COMMUNITY DEVELOPMENT DEPARTMENT  
501 Delta Avenue ♦ Marysville, WA 98270 ♦ (360) 363-8000

April 16, 2024

Re: Undi Commerce Park – *Technical Review 4*  
PA 22008

**SHEET**  
C9 of C13

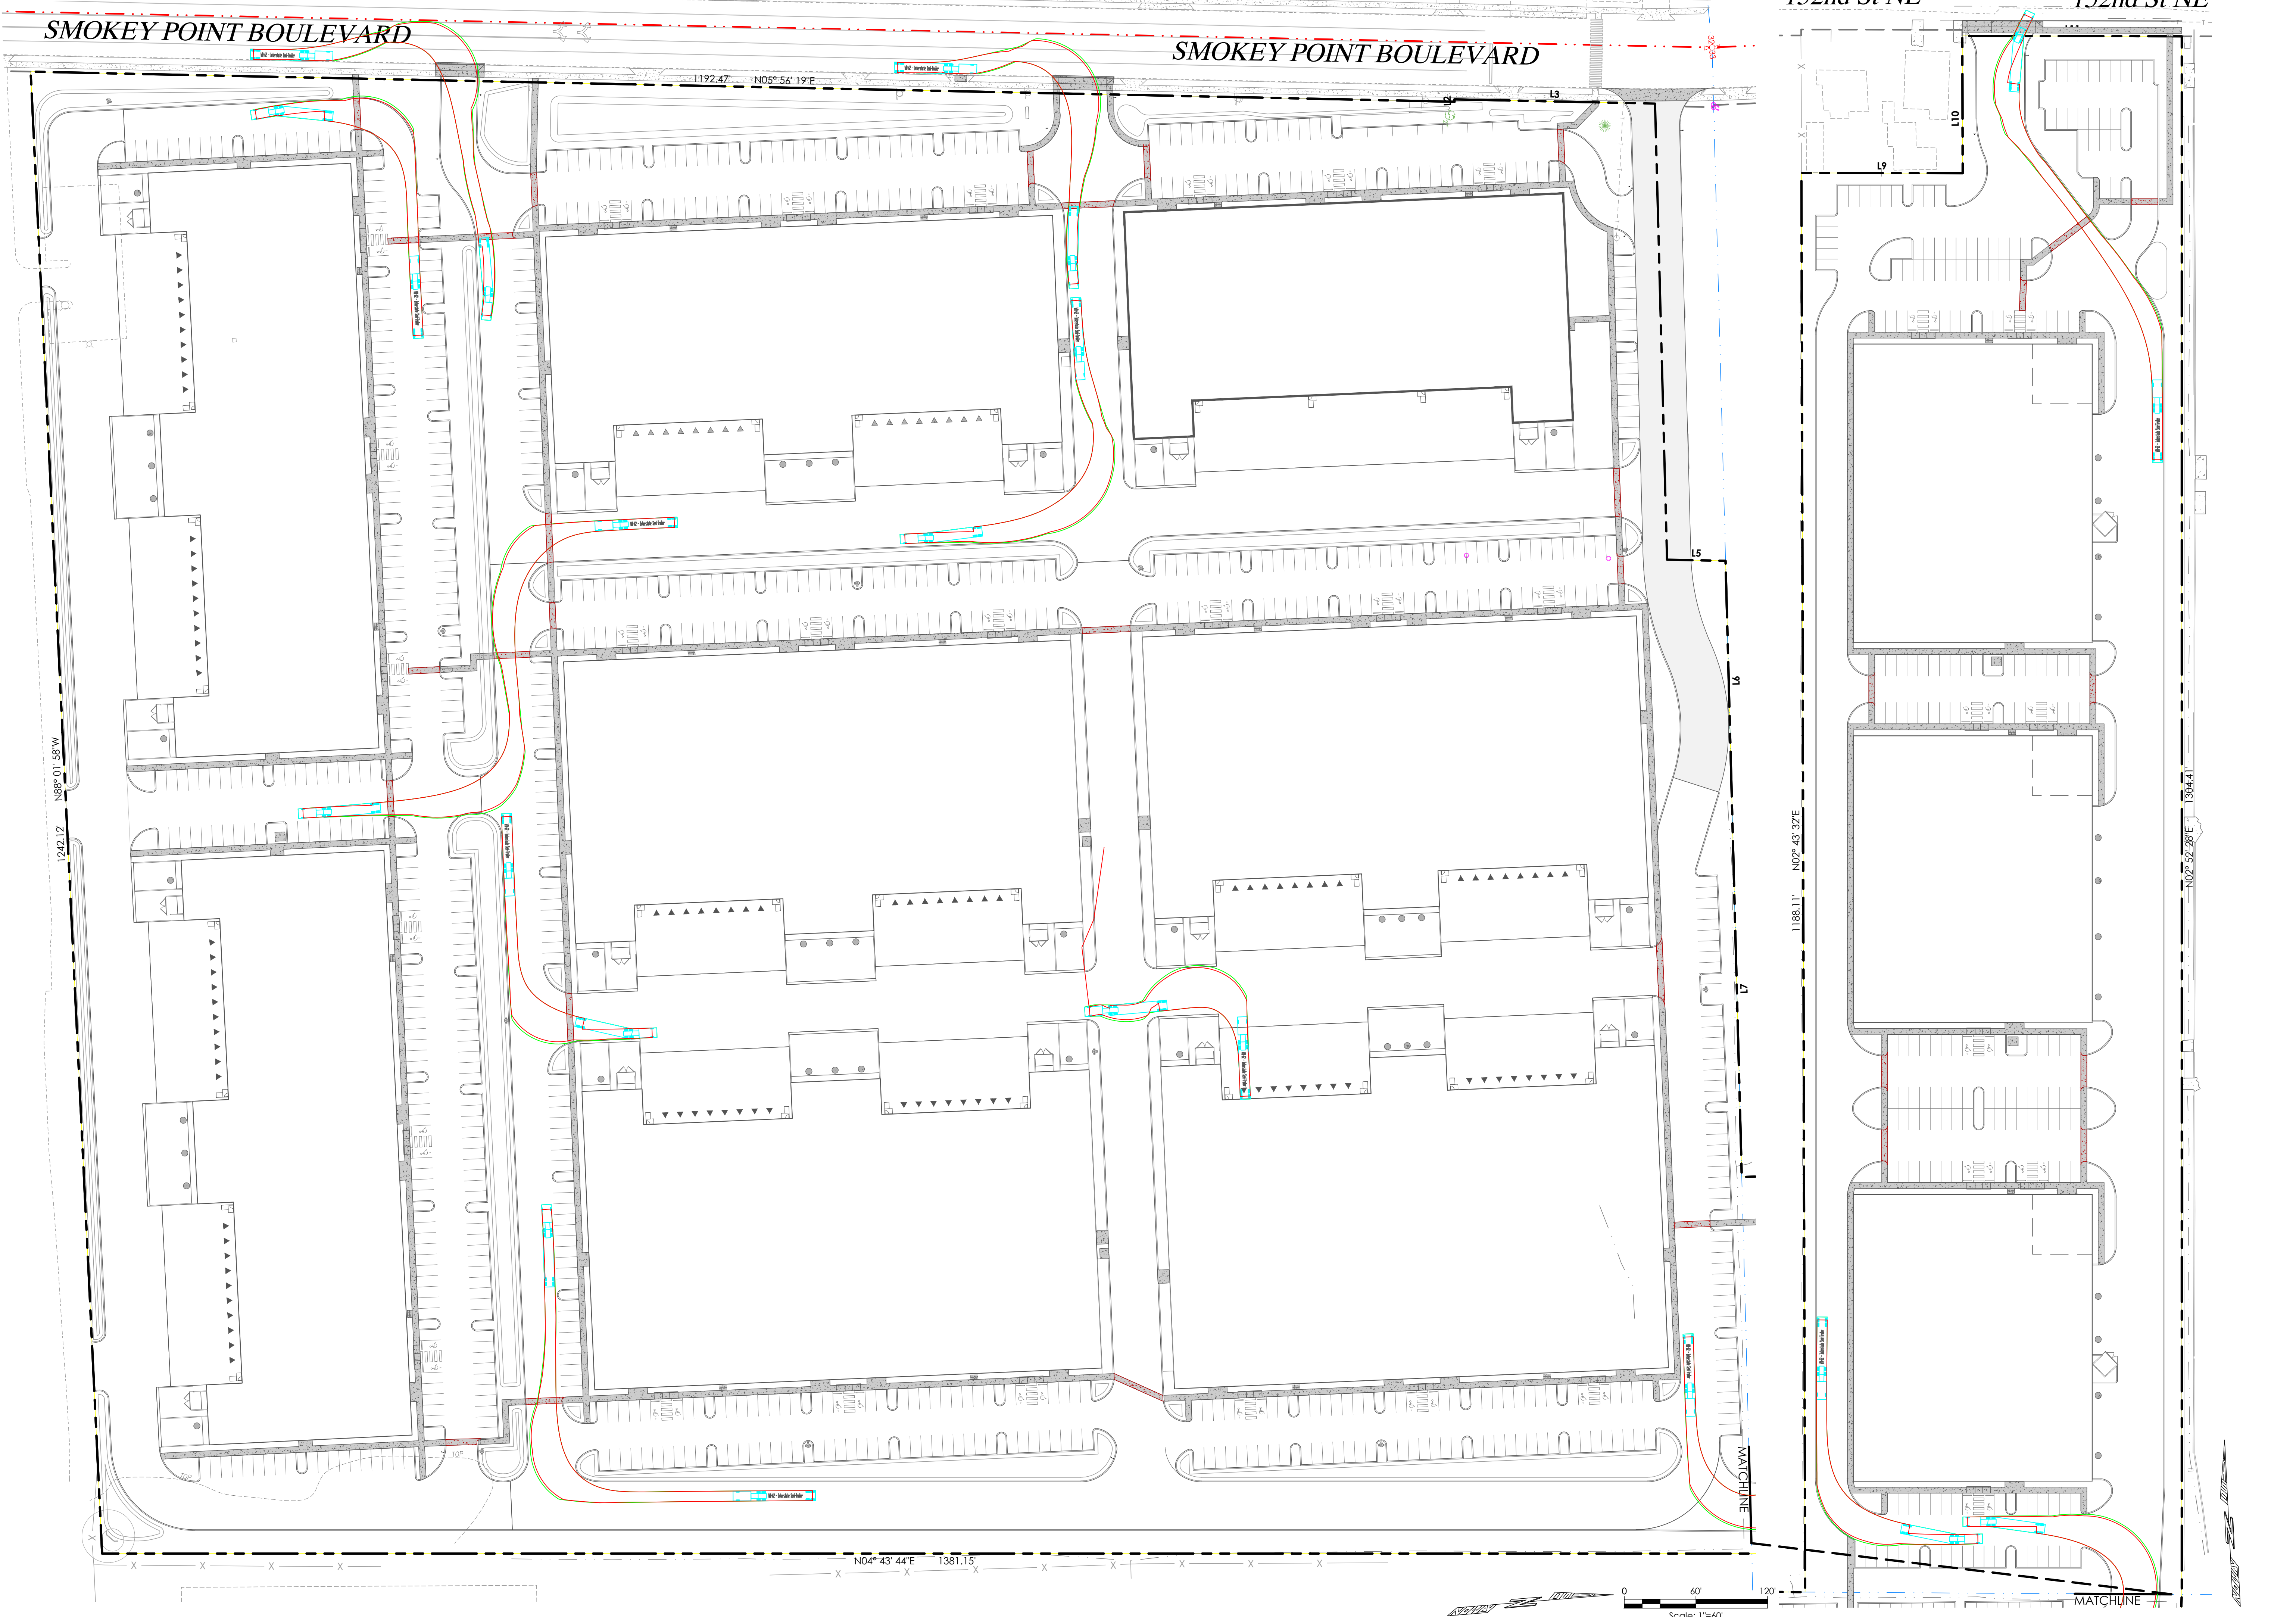
10. **WATER ISSUES:**
- a. Fire hydrants with approved water supply must be in service prior to building construction. **Acknowledged**.
  - b. The number of fire hydrants shall be determined on an average spacing of 300 feet computed on an imaginary line parallel to and not less than 50 feet from the structure. All hydrants are to be accessible to fire department pumpers over roads capable of supporting such fire apparatus (City EDDS 2-060). *Plans show no hydrants available along the north end of the east aisle. Please add two hydrants; between buildings I – J and J – K.*

“Hydrants on the west side of buildings I-j and J-K provide the hydrant coverage required. Five existing hydrants are already located on the east side of the east aisle. These existing hydrants are identified in bold. Hydrant coverage meets the requirements. However, in an attempt to reach approval of the SEPA site plan, two additional hydrants have been added. Modification of these hydrants or use of the existing hydrants may be discussed as a part of civil construction plan review.”

*Understood, as long as the existing hydrants to the east have clear fire access from the new property without any obstructions (ie fence, ditch, vegetation, unmaintained surface).*

- g. Fire hydrant coverage shall be provided along all roads and at intersections. “Fire hydrants meeting city specifications shall be installed on all extensions of the city water system at the time such extensions are constructed. All hydrants shall be owned and maintained by the city. The location and frequency of fire hydrants shall be specified by the city utility department and fire department; provided, that fire hydrants in commercial and industrial zones shall be spaced not more than 300 feet apart” (MMC 14.03.050).

“Hydrants are included on sheet C8. It should be noted that there are many existing hydrants along the East edge of site that meet the requirements here but two additional hydrants have been located on this plan to reach approval of the sepa site plan.”

*Understood, thank you.*

Conceptual Midblock Crossing Layout

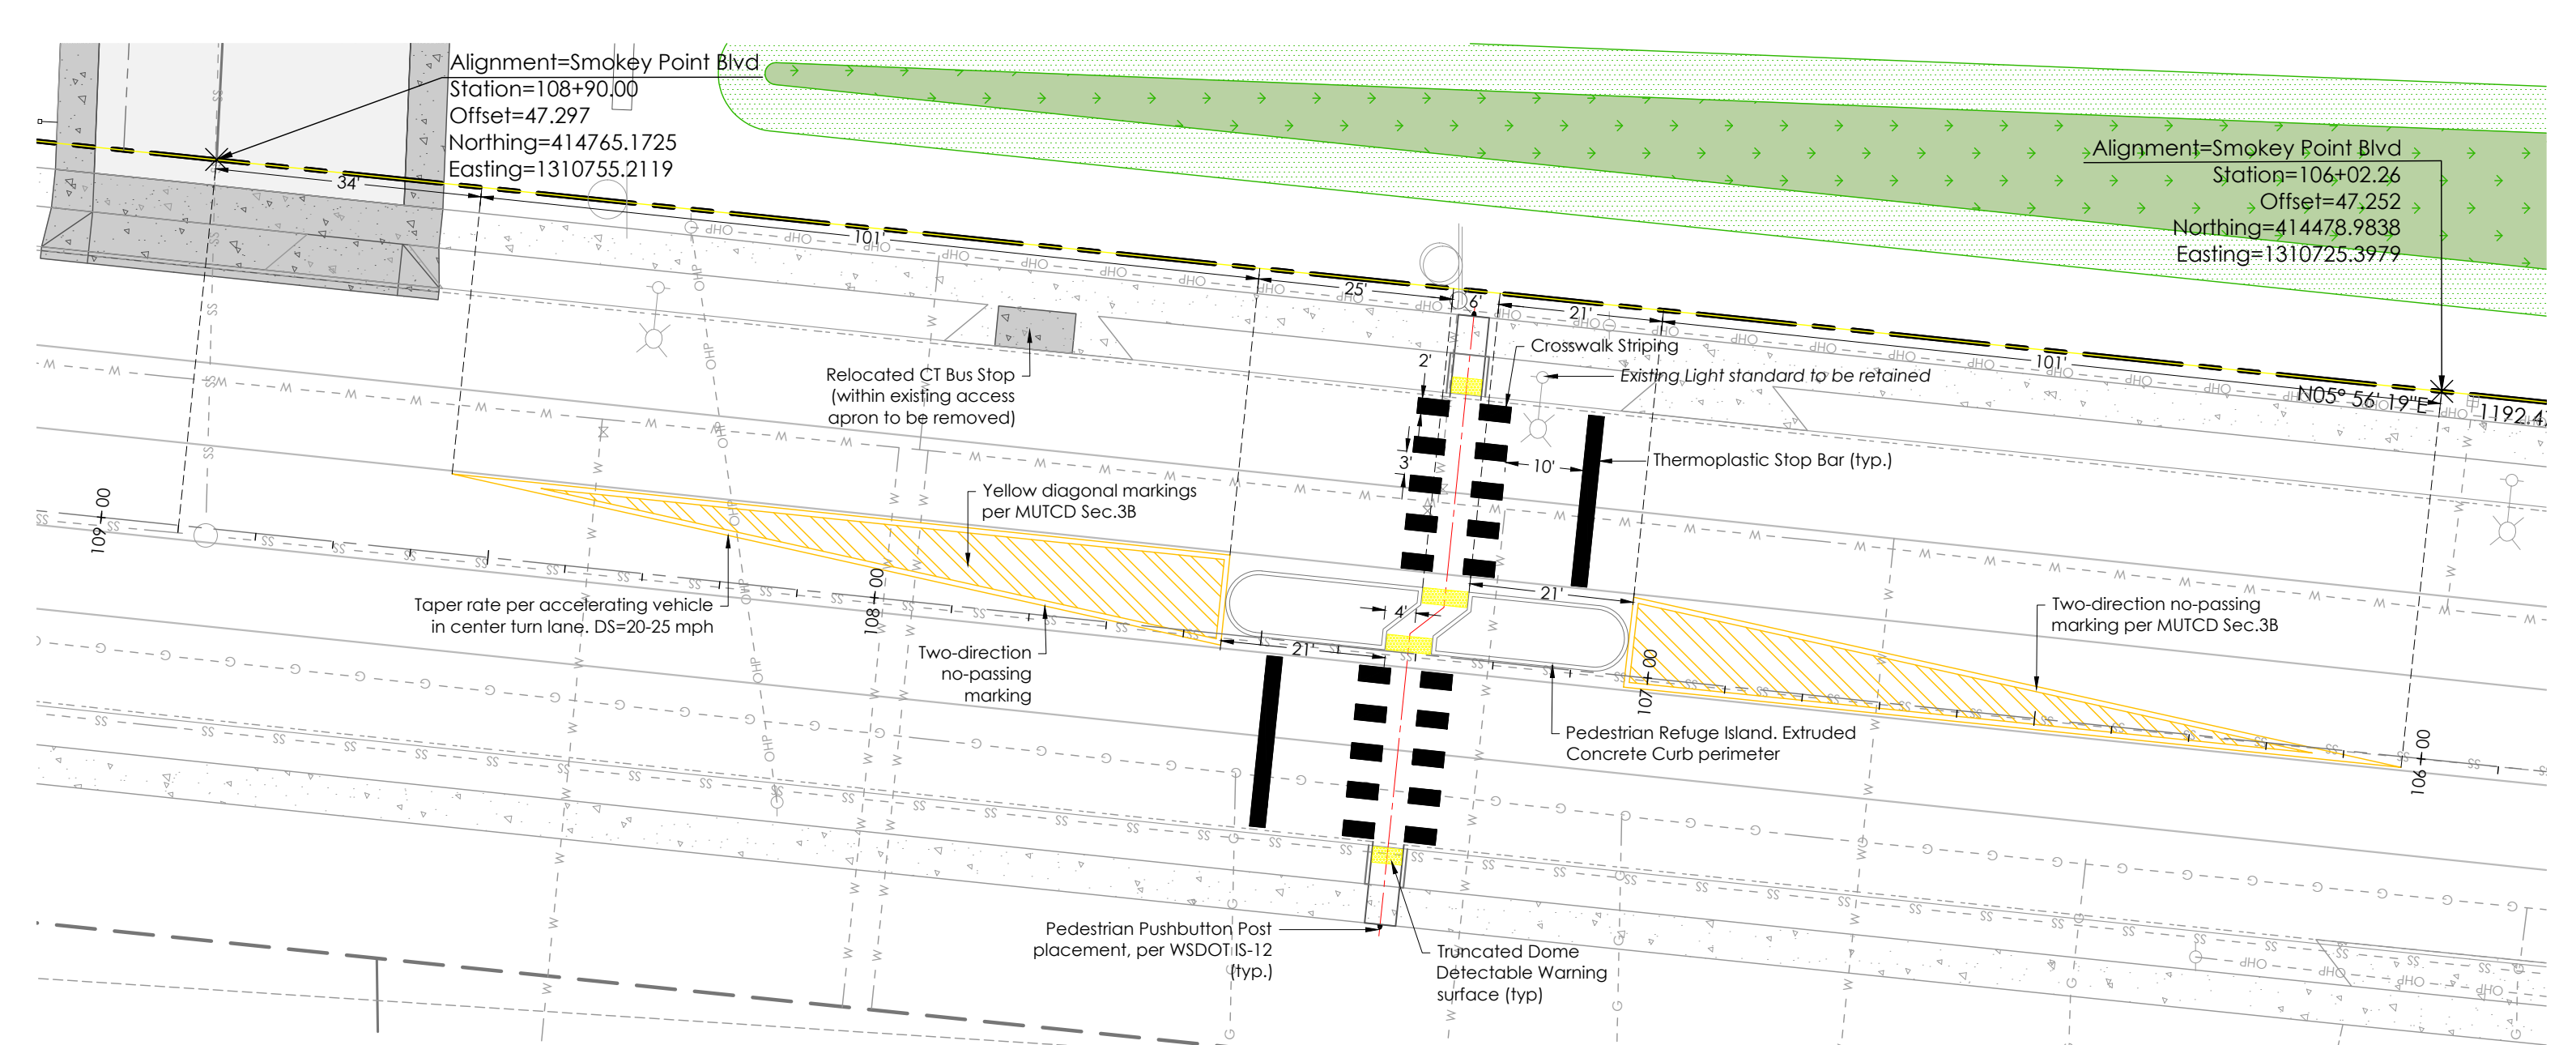
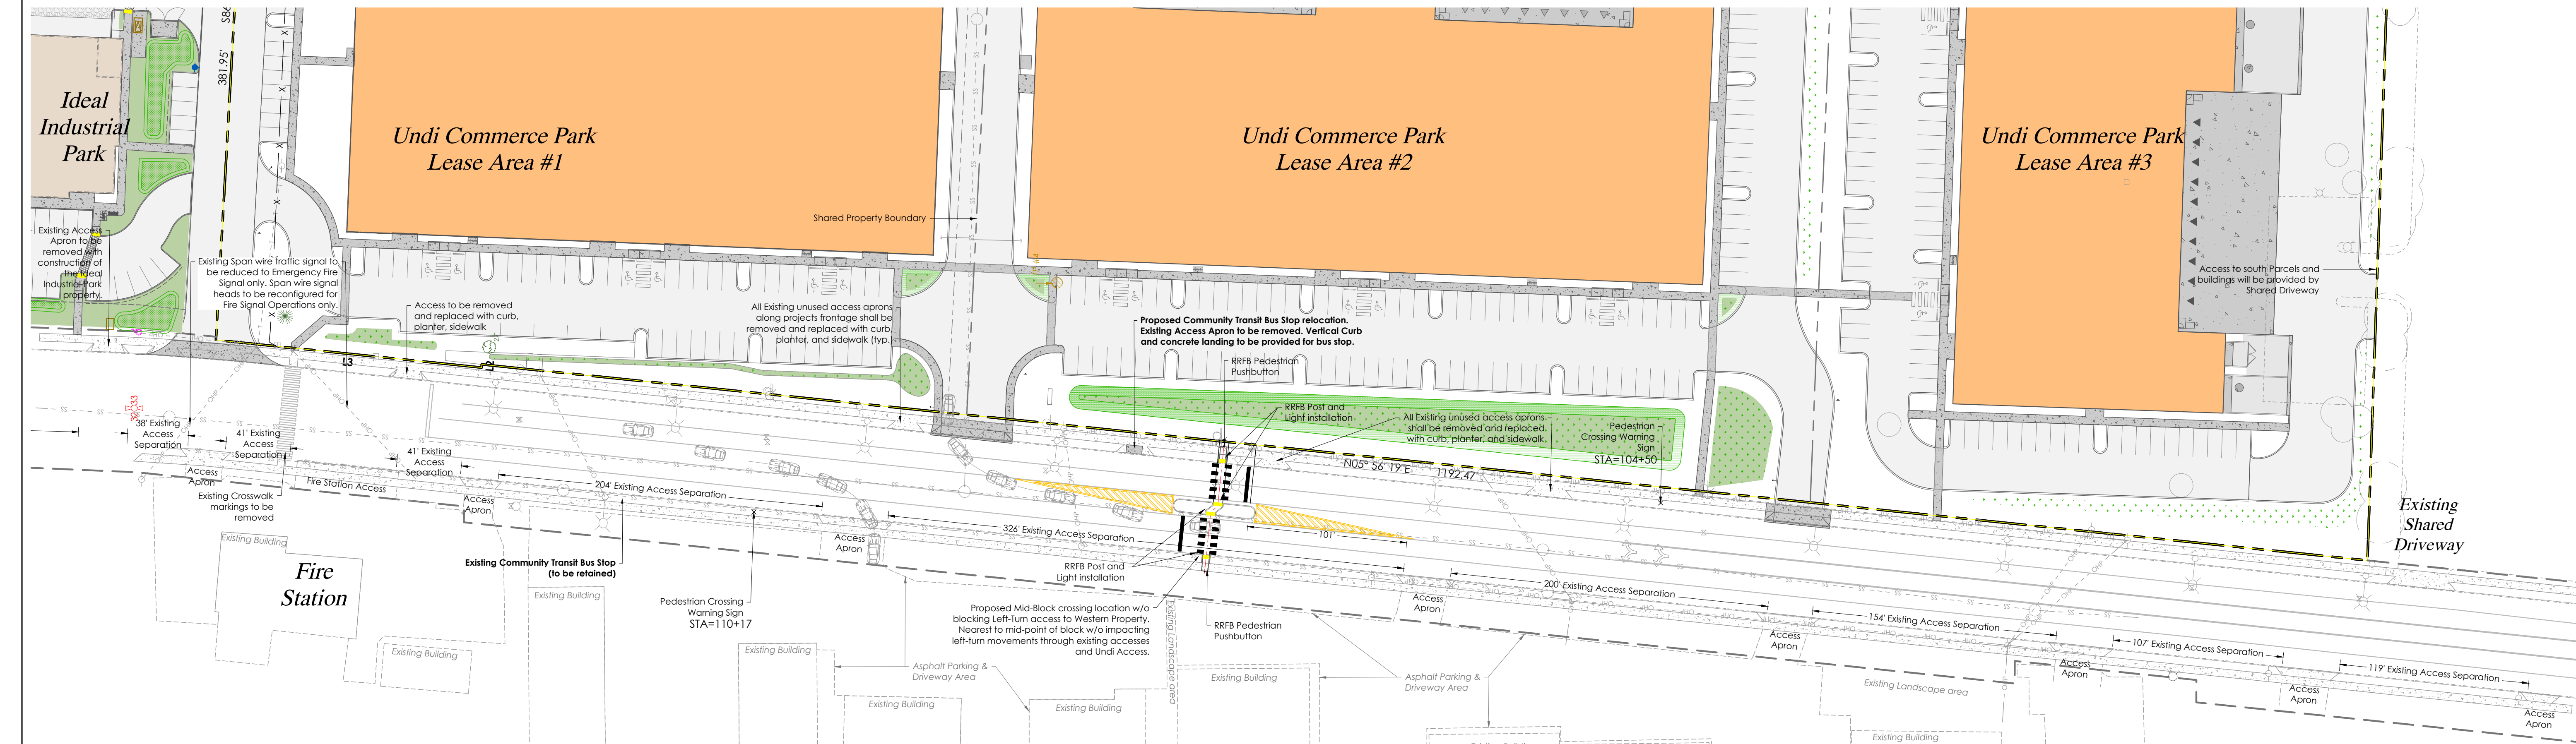
- i. Reconfiguring span wire signal heads to provide for fire signal operations only.
          - ii. Relocating the existing pedestrian crosswalk contained within the traffic signal operations to the south at proposed location with the installation of a marked two-stage offset mid-block crosswalk with RRFB systems.

- A. Offset shall be increased to a minimum of 10' and maximum of 20' to provide greater separation of 2 RRFB systems with pushbuttons in median to have minimum separation of 10' per ADA.

- B. Given location of street light on east side of roadway, move crosswalk across northbound traffic further to south to provide for pedestrians/vehicles to not have view blocked by decorative street light pole.

- C. Specifications and details for RRFB systems shall be requested by civil design engineer for inclusion into civil plans.
          - iii. CT Bus Stops on both east and west side of Smokey Point Blvd. will need to be relocated to be near relocated crosswalk with RRFB. Preference for far-side bus stops in each direction to provide for less delay to transit if pedestrians immediately desire to cross Smokey Point Blvd. at RRFB.

7. Community Transit Comment Response:
- a. Northbound Bus Stop should be moved north of proposed development access point to reduce opportunities for a stopped bus to block visibility for drivers existing the Undi driveway.

- b. Southbound bus stop shall be relocated to south of proposed marked crosswalk location per diagram provided on 3/19/24.
  - c. RRFB systems are shown to with proper design be as or nearly as effective as HAWK signals at significantly less cost, therefore the RRFB systems shall be acceptable.
